## POST EPC MEMORANDUM

TO: CABQ Development Facilitation Team (DFT)  
FROM: William Steele, Senior Planner  
DATE: 05/08/25  
RE: PR-2024-011052, SI-2024-01468 – Site Plan – EPC

ELECTRICAL SITE PLAN

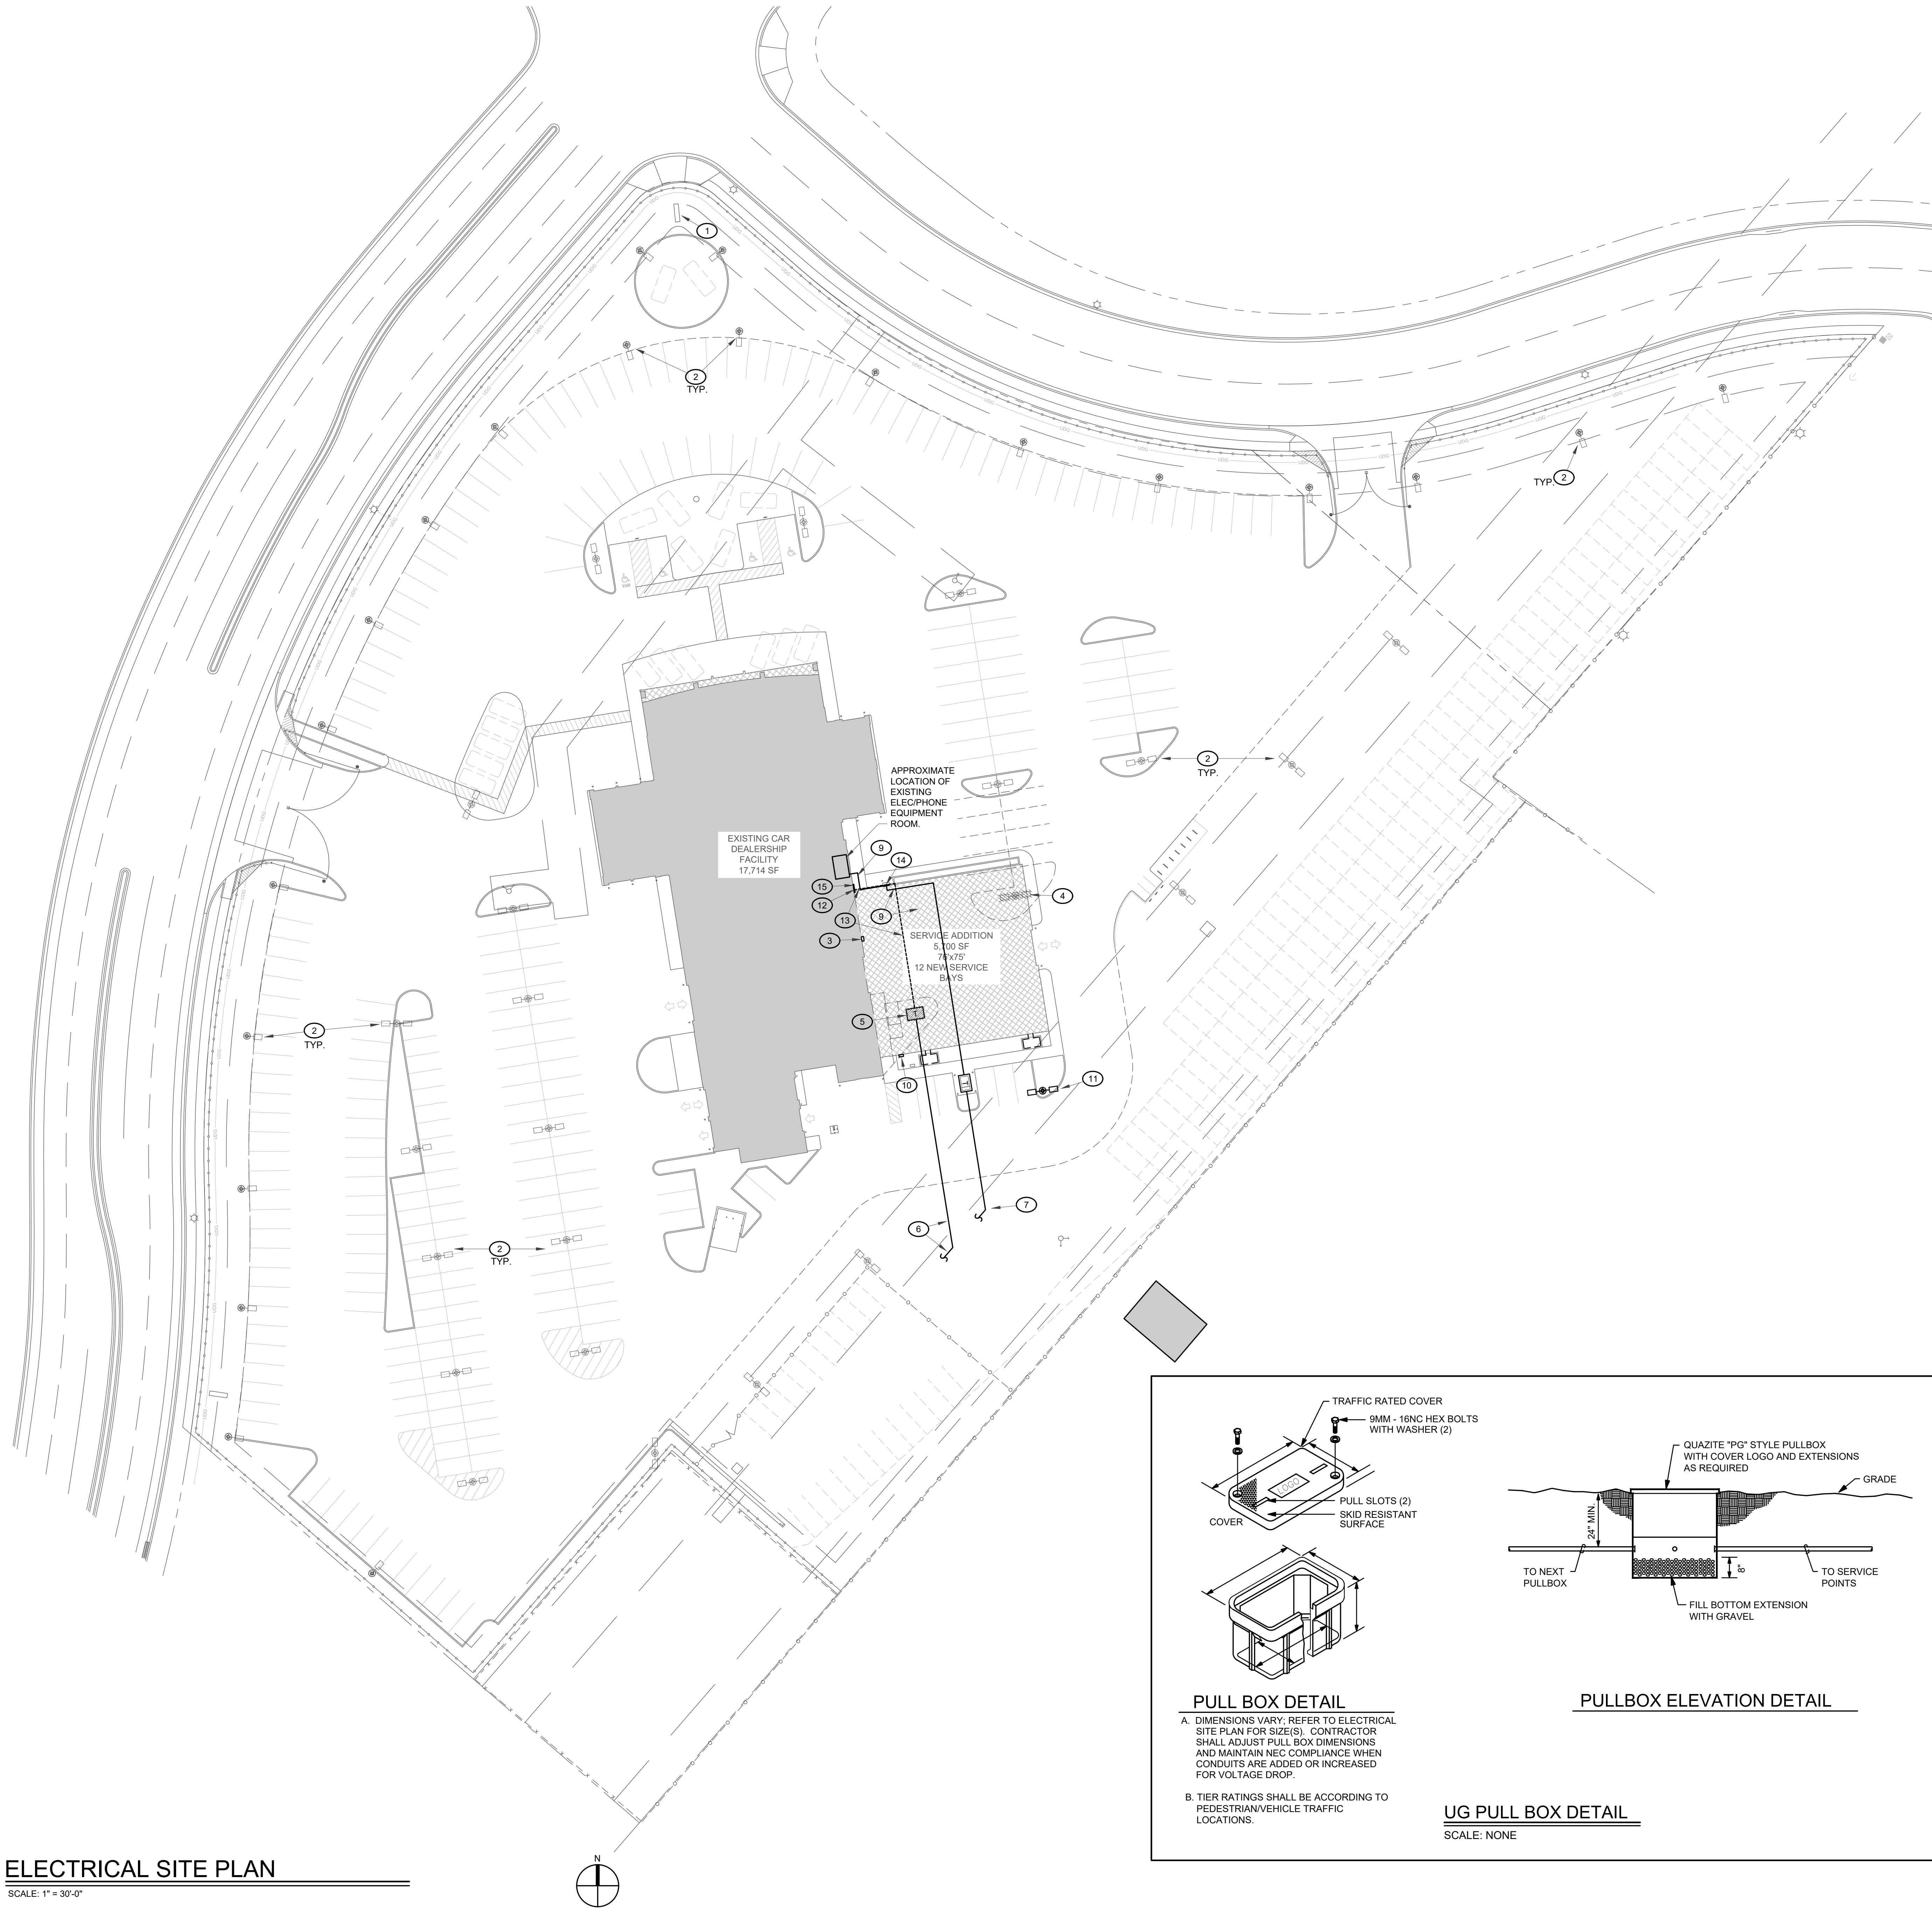
8. The site lighting shall come into compliance with the Outdoor and Site Lighting standards of IDO §14-16-5-8 or the applicant shall show how the existing outdoor lighting complies with the IDO. A site lighting plan shall be provided to city staff prior to sign off. If the applicant is unable to comply with IDO §14-16-5-8 they shall return to EPC for an outdoor and site lighting performance analysis.

*The applicant has provided an ELECTRICAL SITE PLAN sheet (ES1.0) which the existing and relocated locations of the electrical equipment, lighting (site lighting) and signs are shown on the site. Pull Box and Pole Base Mounting details are shown on the plan.*
